Date: 23 March 2018
Your Ref: A/11/OUT and A/23/15/OUT
Our Ref: 9349

OBJECTION TO APPLICATIONS A/11/17/OUT AND A/23/15/OUT RELATING TO LAND SOUTH OF NEW ROAD (A259) AND EAST OF BROOK LANE ANGMERING

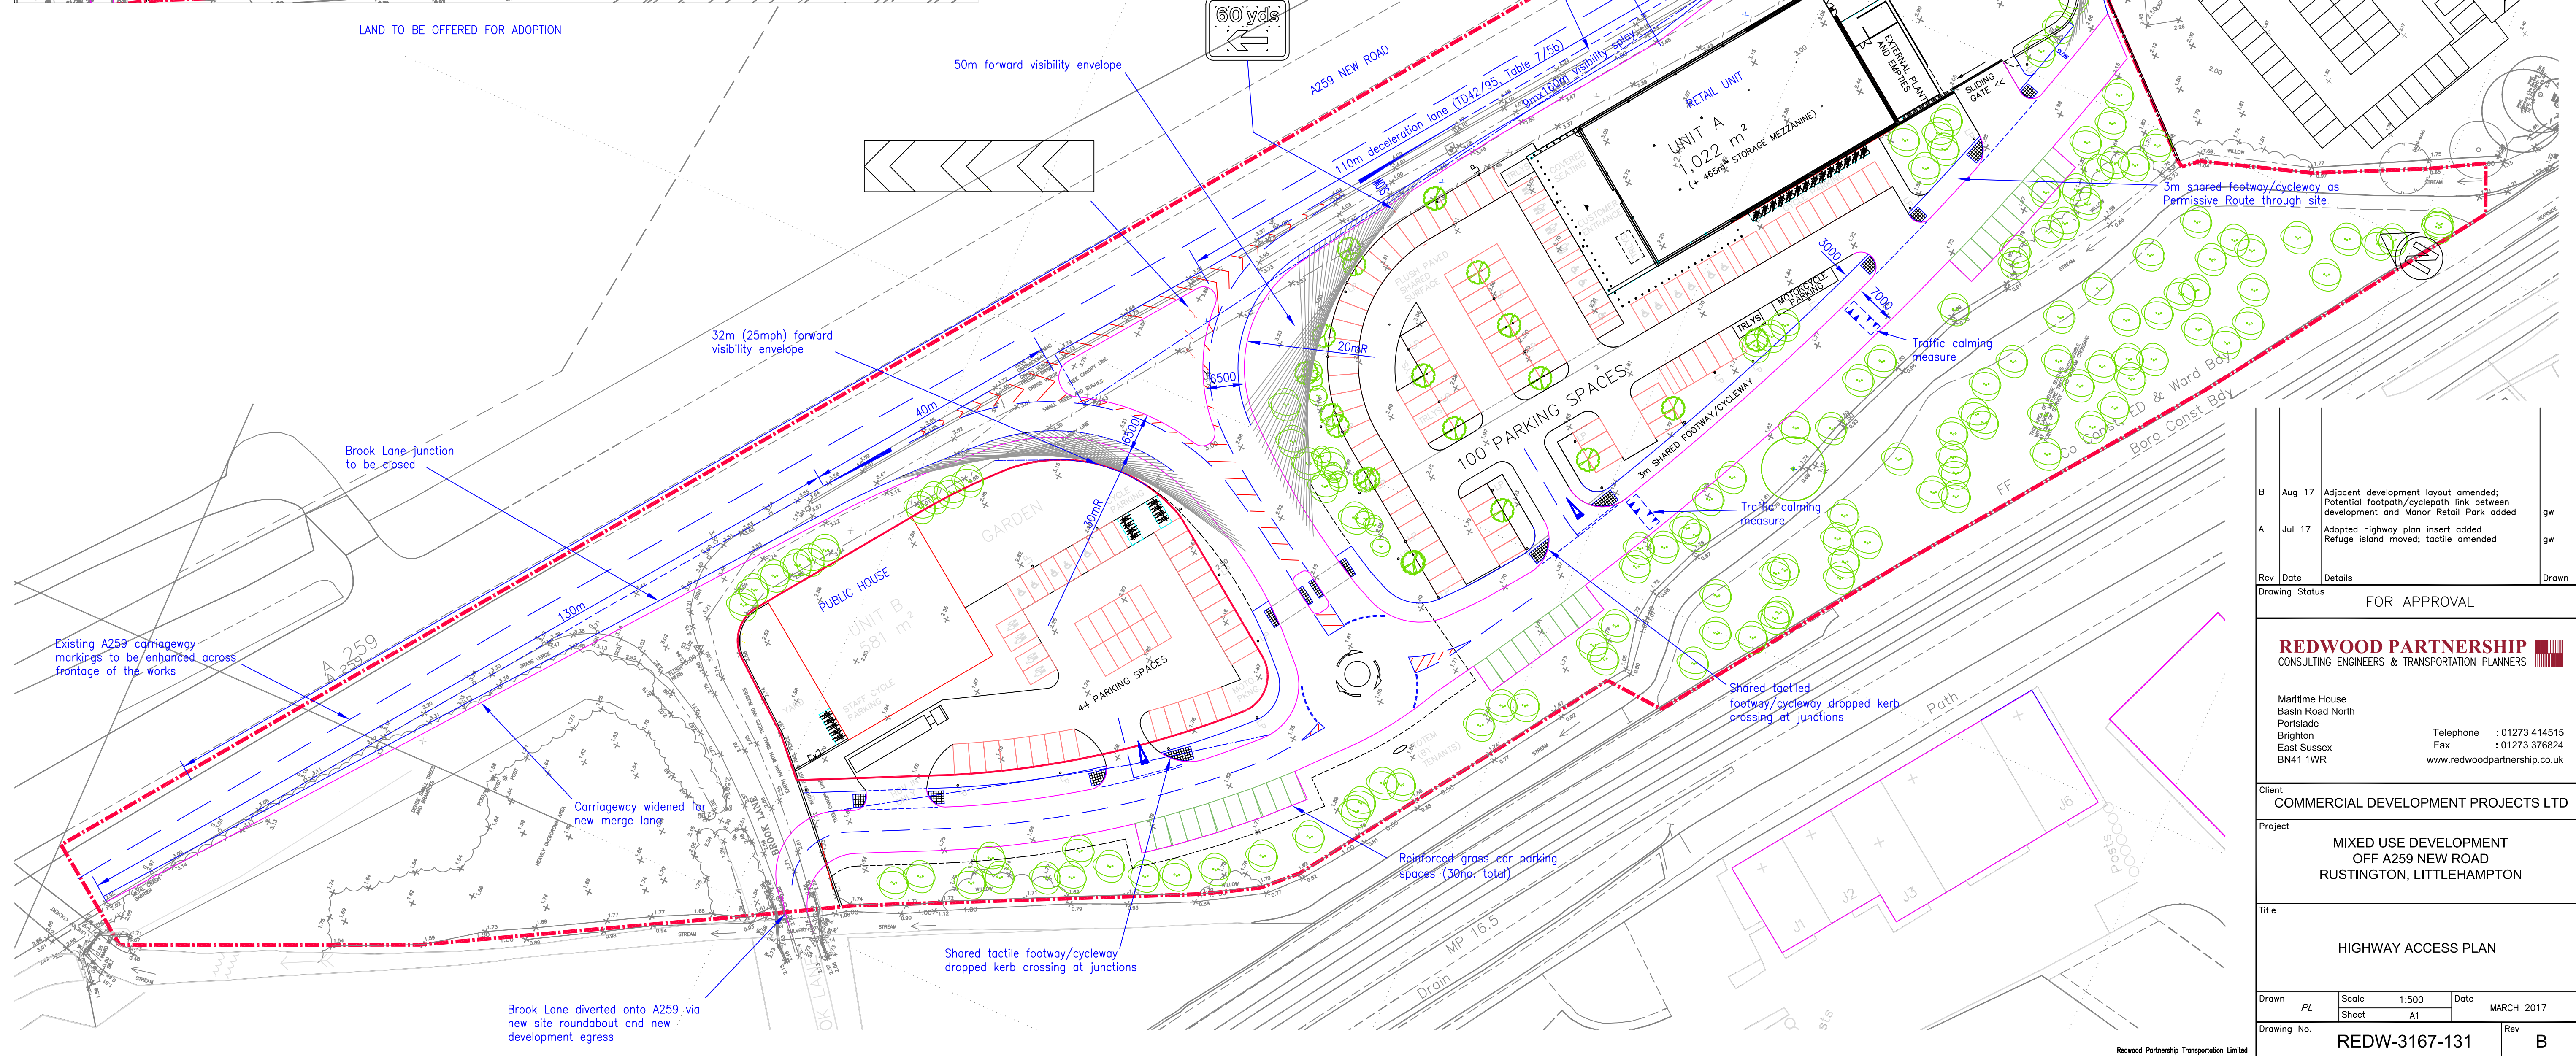
The advice from WSCC is that they would not adopt the internal roads. SDB’s access plan (REDW-3167-131B) therefore needs to be updated as it currently states that the routes would be ‘offered for adoption’. Either the scheme needs to change prior to determination to ensure that adoption is a realistic probability, or the applicants should ensure that the implications of their design are properly understood. In particular, we consider that the access proposed would not be suitable for the residential scheme which is a committed development. A residential scheme of the size proposed on my client’s site would need a road built to the boundary which was at the very least built to adoptable standards. If the road is not going to be adopted, this is likely to reduce the attractiveness of the site to residential developers and therefore threaten the delivery of new homes which would make a valuable contribution to the Council’s housing land supply.
